Add to First Lutheran Church

CITY OF PORTLAND, MAINE
 DEVELOPMENT REVIEW APPLICATION
 PLANNING DEPARTMENT PROCESSING FORM

I. D. Number
 20010012

RE: First Lutheran Church - ID #20010012, CBL #374-A-13
Response to letter from J. Spence dated March 12, 2001

SHEET TITLE
**SITE PLAN
EROSION AND
SEDIMENTATION
CONTROL MEASURES**

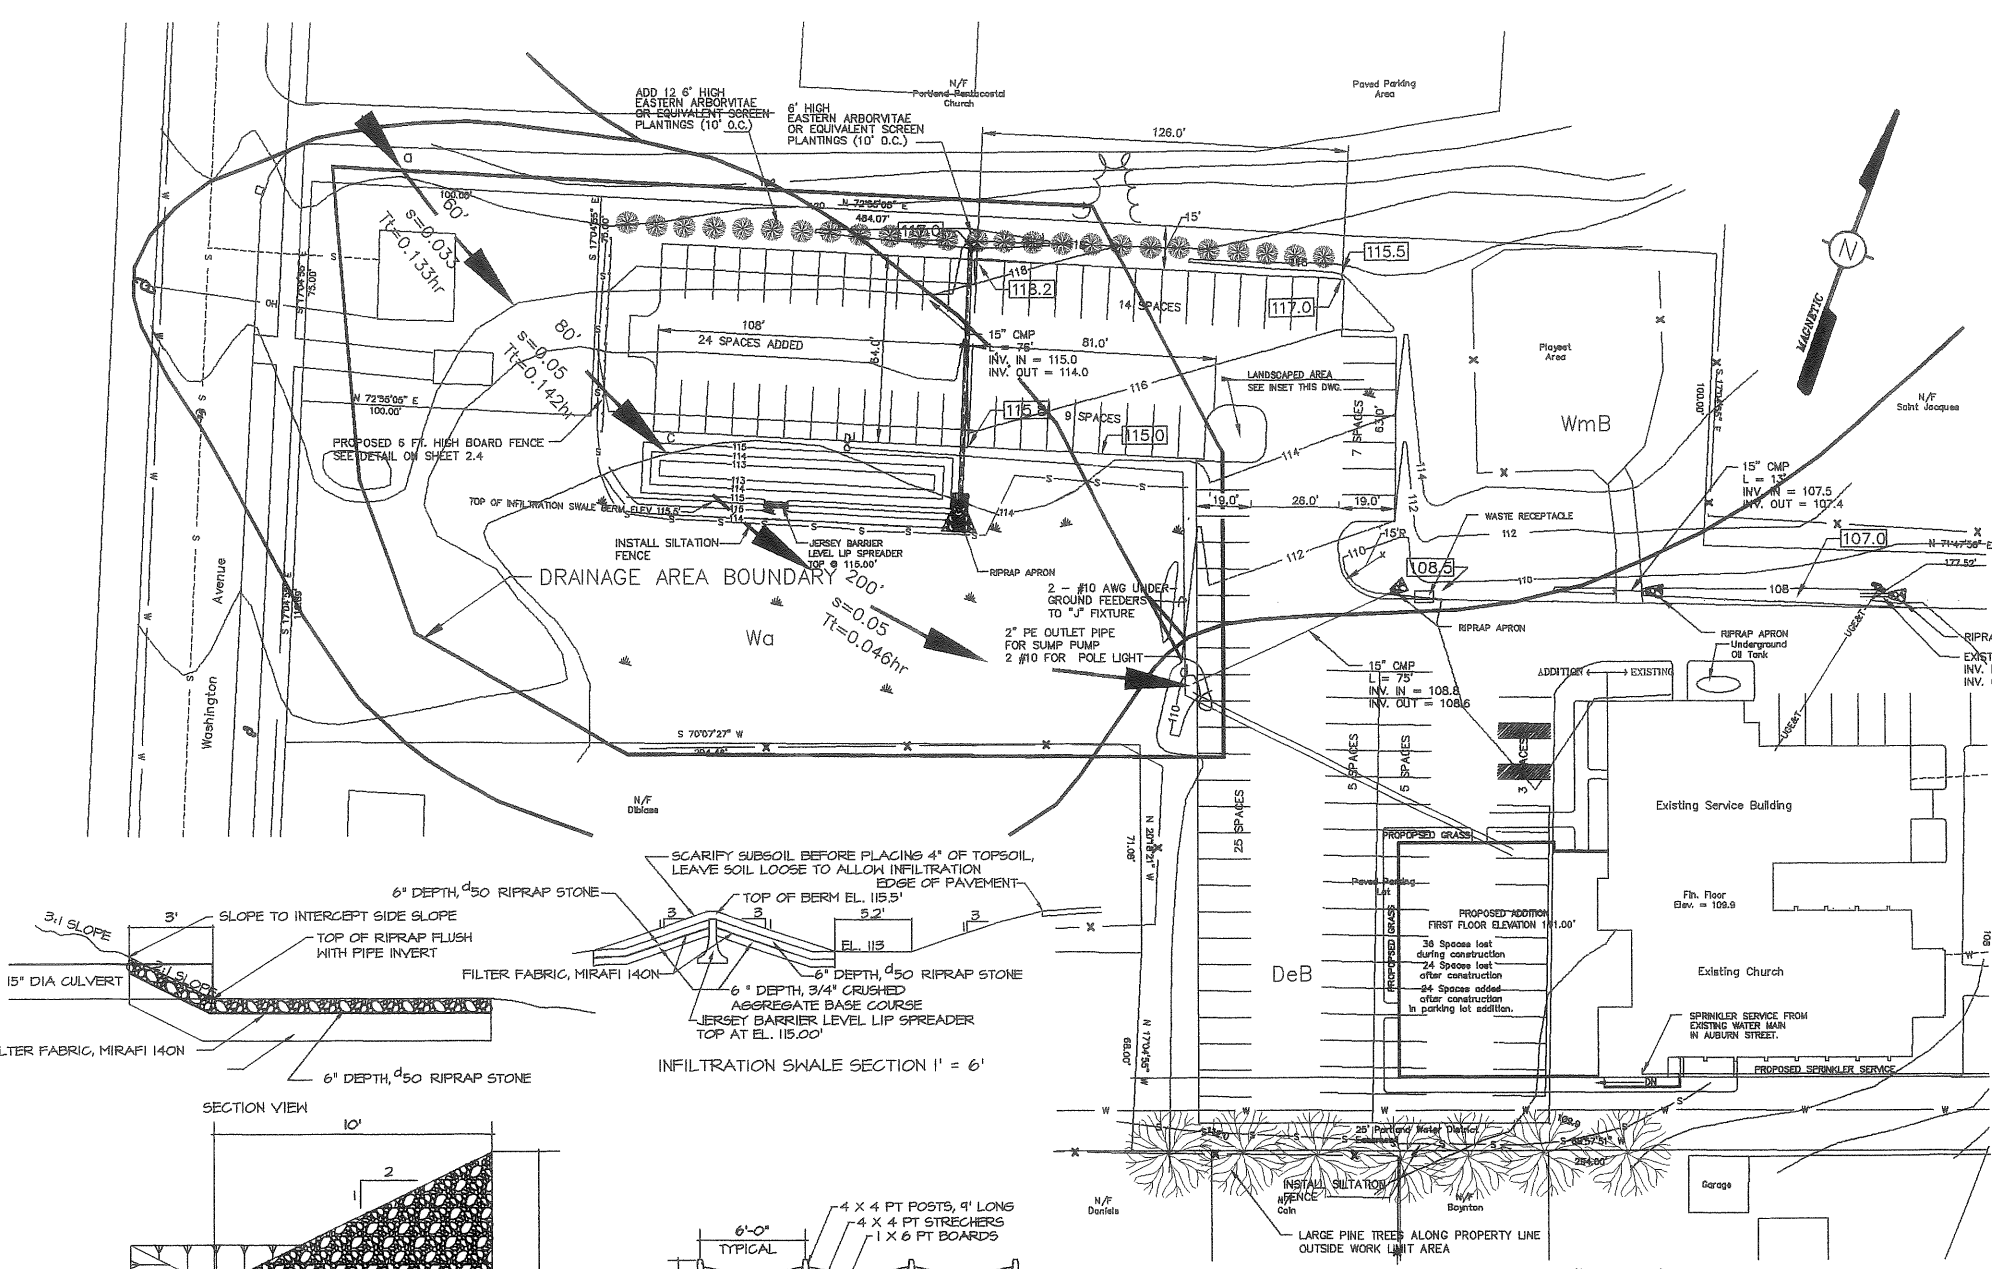
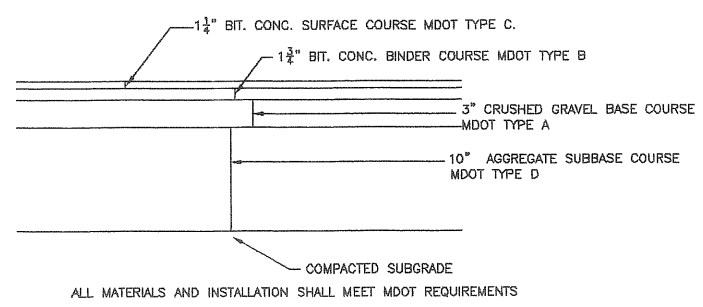
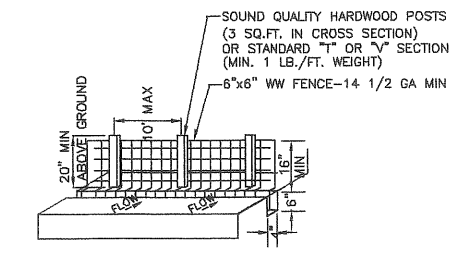
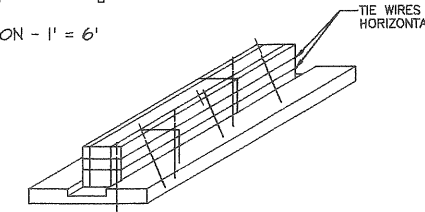
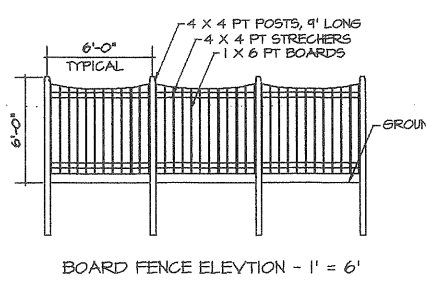
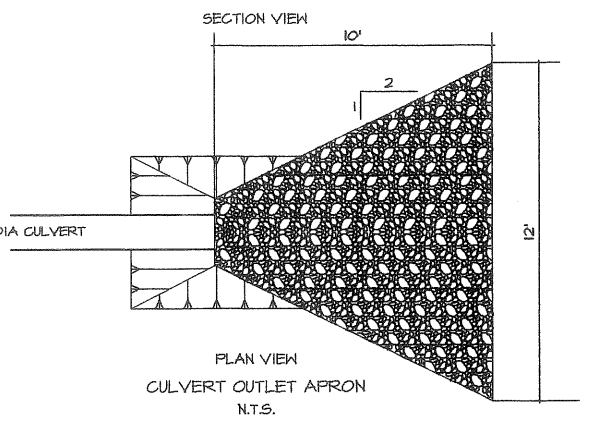
6.c. A storm water quality swale is shown on Sheets 2.2 and 2.4, being delivered by messenger. This treatment swale is designed to catch the runoff from the added pavement to allow sediment to settle and storm water to infiltrate into the underlying soil. A level lip spreader is designed to allow the 10-year storm to overflow. Calculations are included in the submittal.

SHEET TITLE
EXTERIOR ELEVATIONS

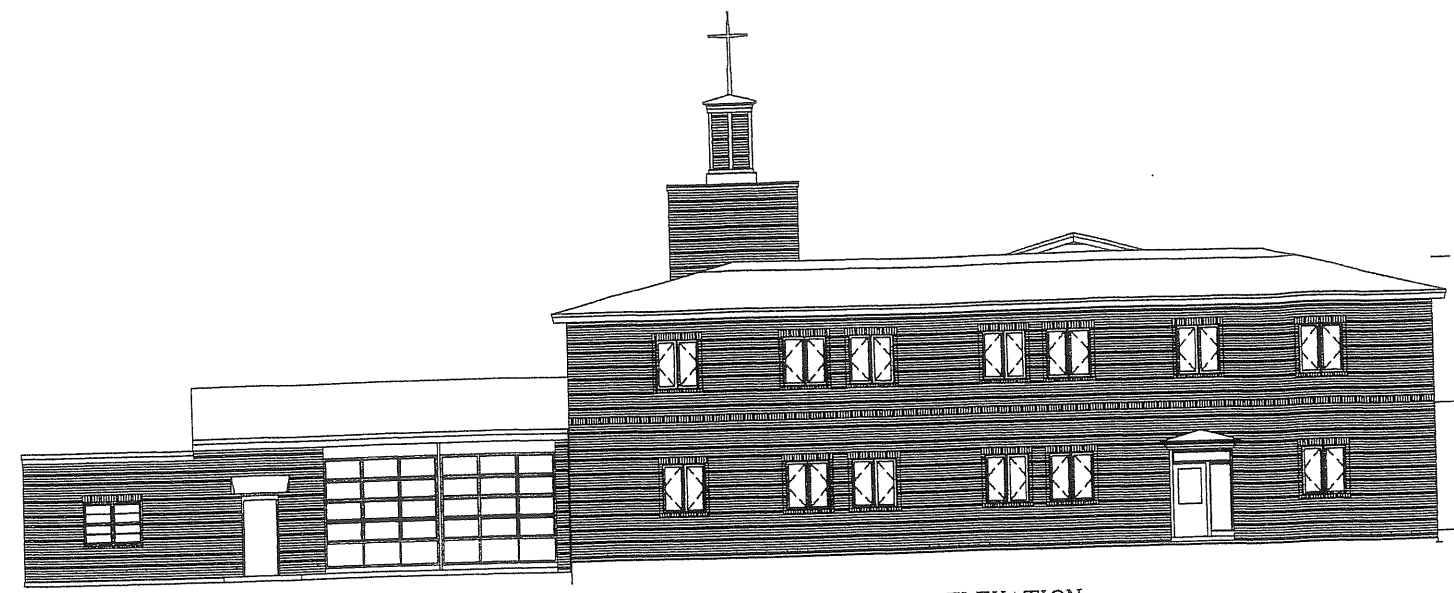
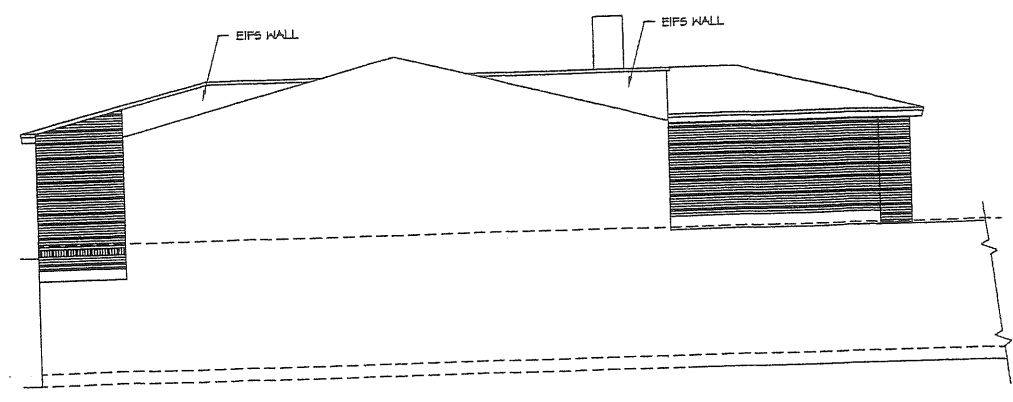
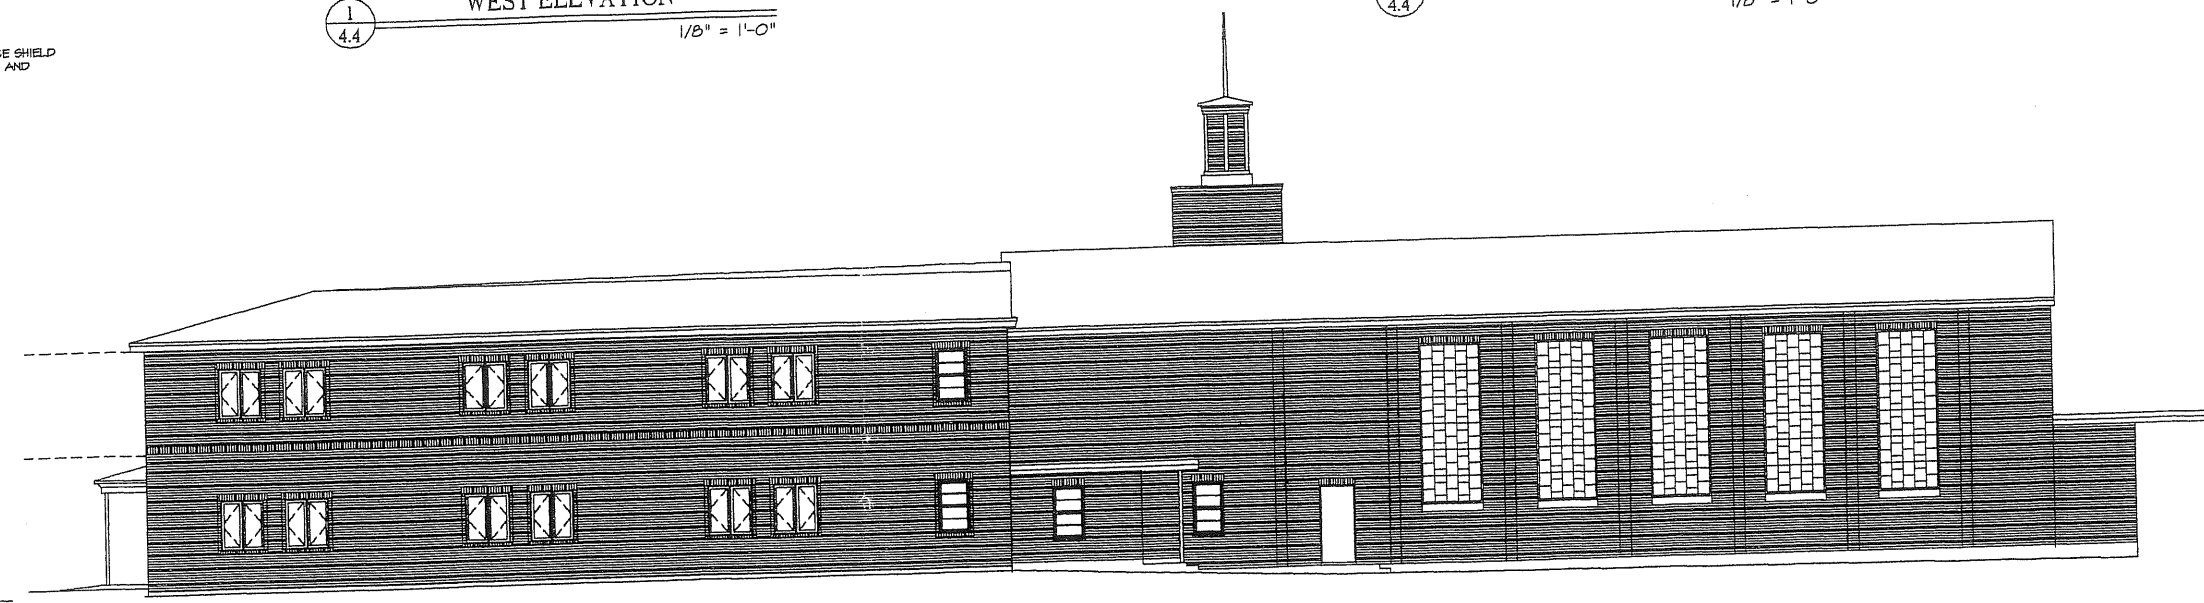
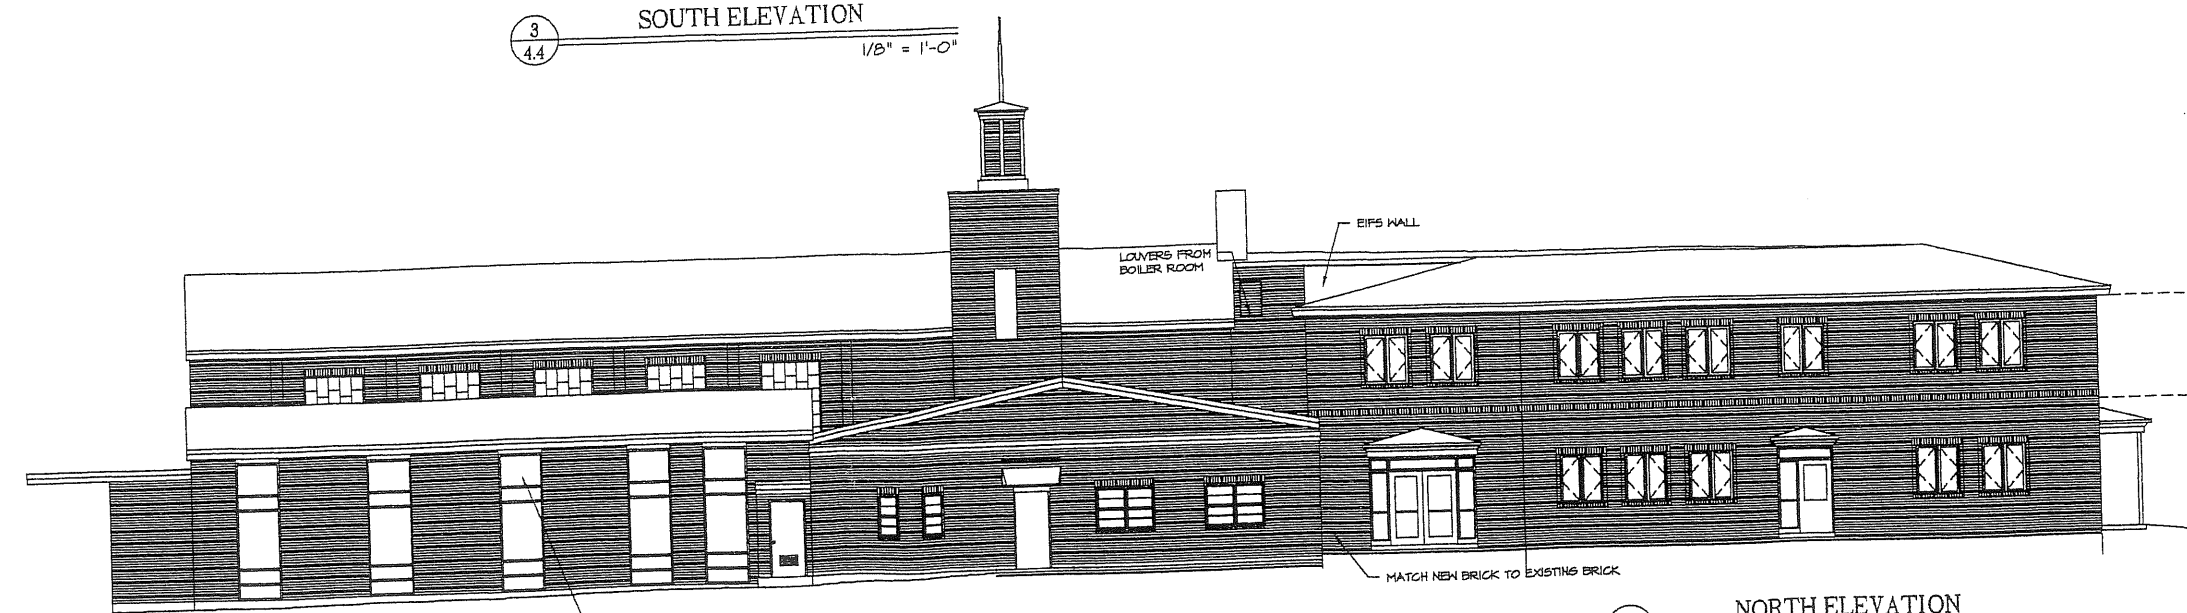
The applicant is proposing to construct a two-story addition with a pitched roof. The brick exterior will match the existing brick. Entrances to the new addition will be canopied. The addition appears to be compatible in terms of style and materials with the existing building.

PROPOSED 6 FT. HIGH BOARD FENCE
SEE DETAIL ON SHEET 2.4

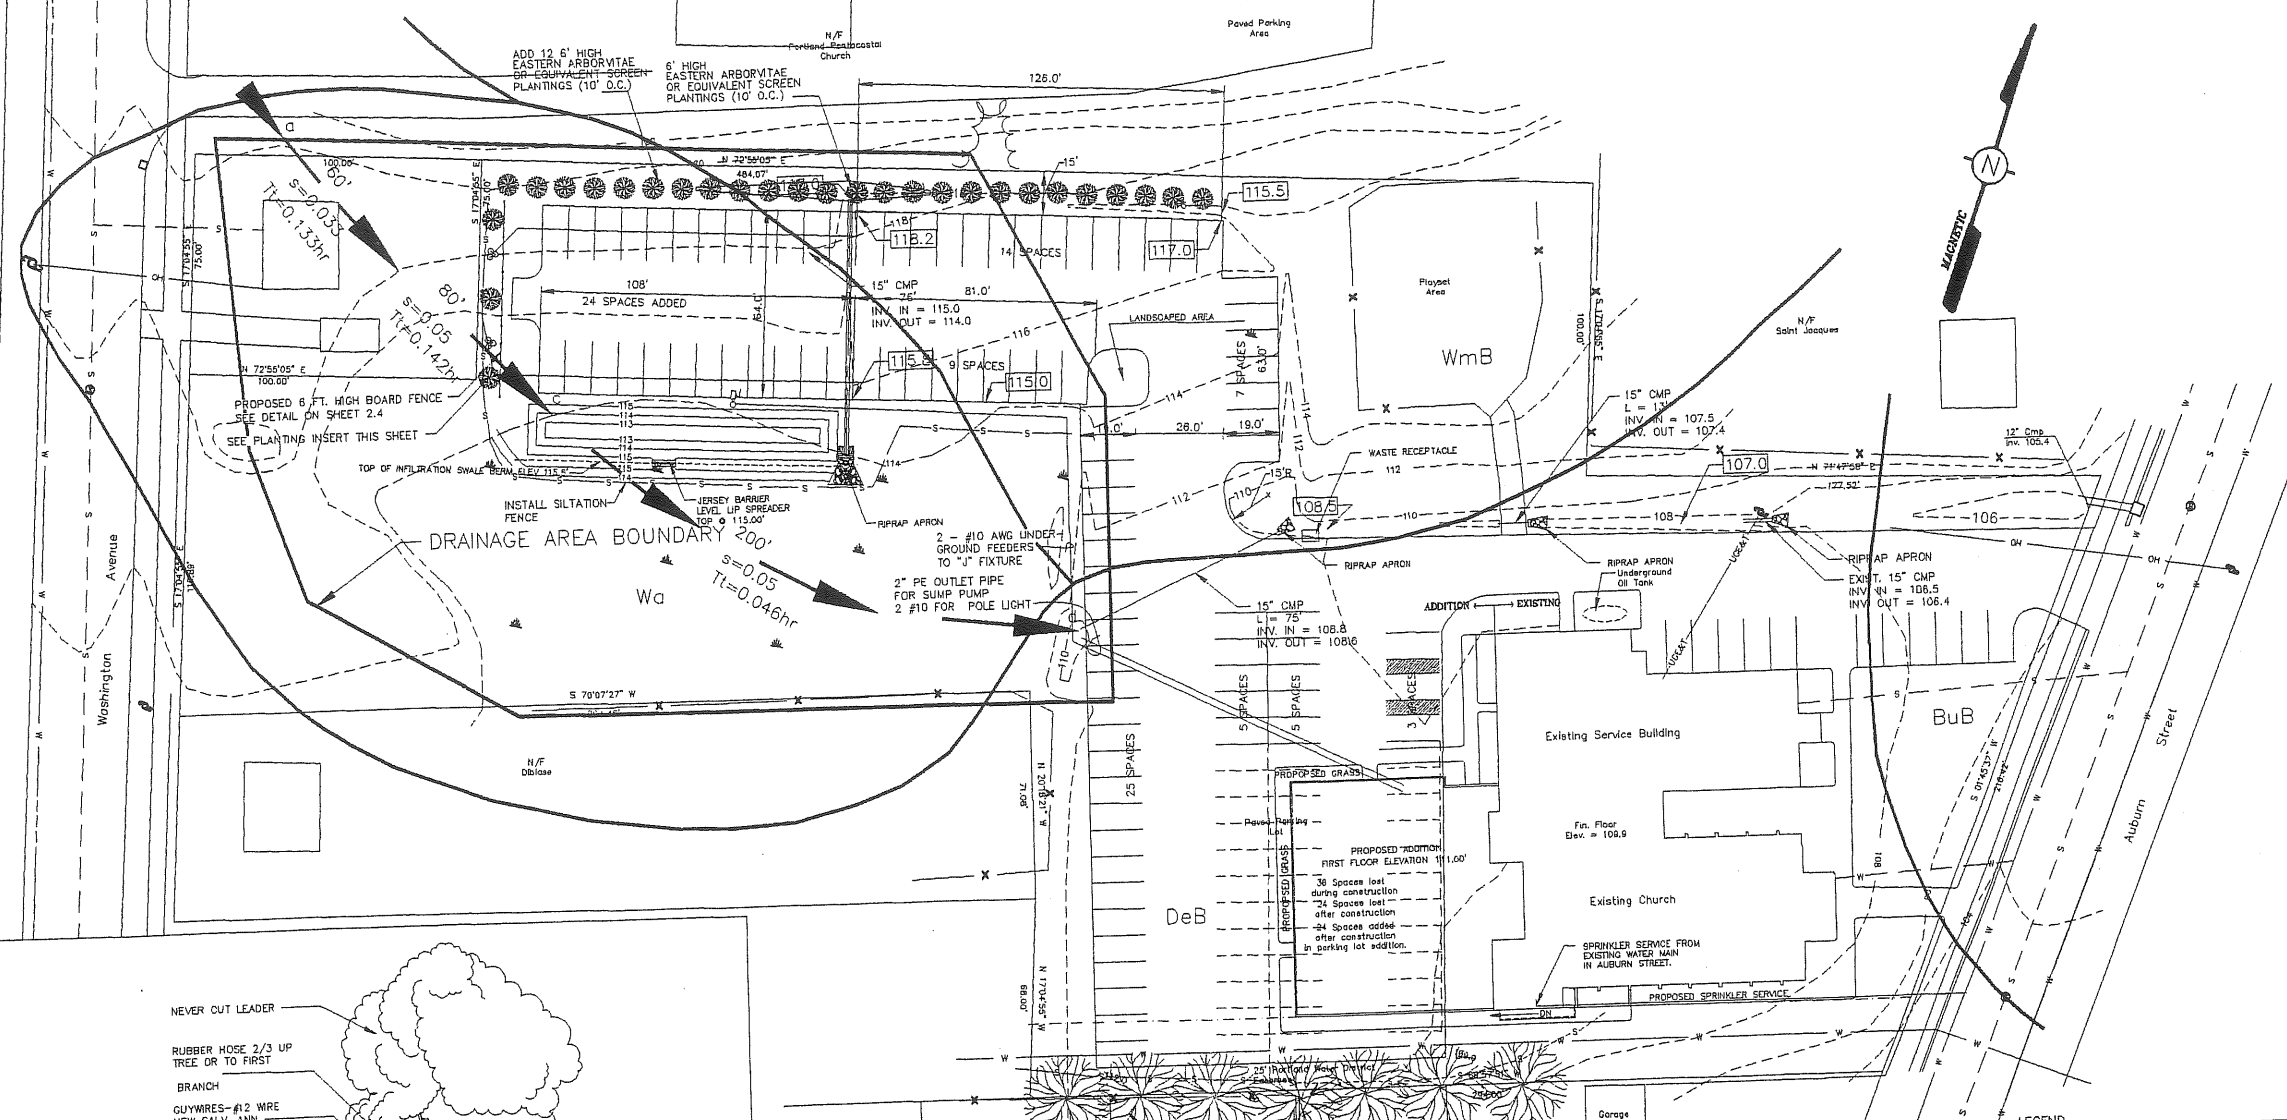
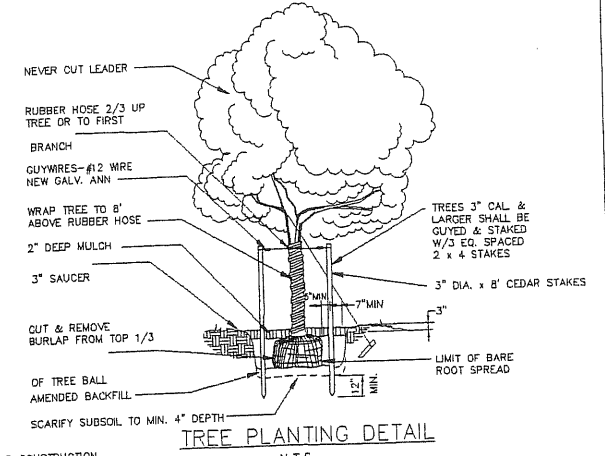
The applicant intends to preserve the existing trees located to the south of the proposed addition. Arborvitae along the northern perimeter of the new parking area. Per staff's request, the applicant has included a 6' high board fence at the western end of the new parking area. Staff would ask that planting be designated on the landscape plan for both sides of this fence.

- i. that the site plan be amended to designate the land at the west end of the new parking lot as an area to remain free of snow storage and that the area to the south of the lot be specified as a snow storage location.
- ii. that the landscaping element of the site plan be amended to include the placement of 6' high Eastern Arborvitae 10' on center between the parking area and the western property line behind the proposed addition.

2. Photometrics for Fixture Type J mounted in a 20 ft. pole are being delivered by messenger. 3. Delivered by messenger is a copy of Sheet 2.4 showing a board fence along the west end of the parking lot extension. I disagree with the added planting recommended by staff. The plantings will be continually damaged by snow removal. 4. The trees to the south of the proposed addition are along the property line beyond the Portland Water District right-of-way and are well outside the construction work lines. No protection of them is needed.
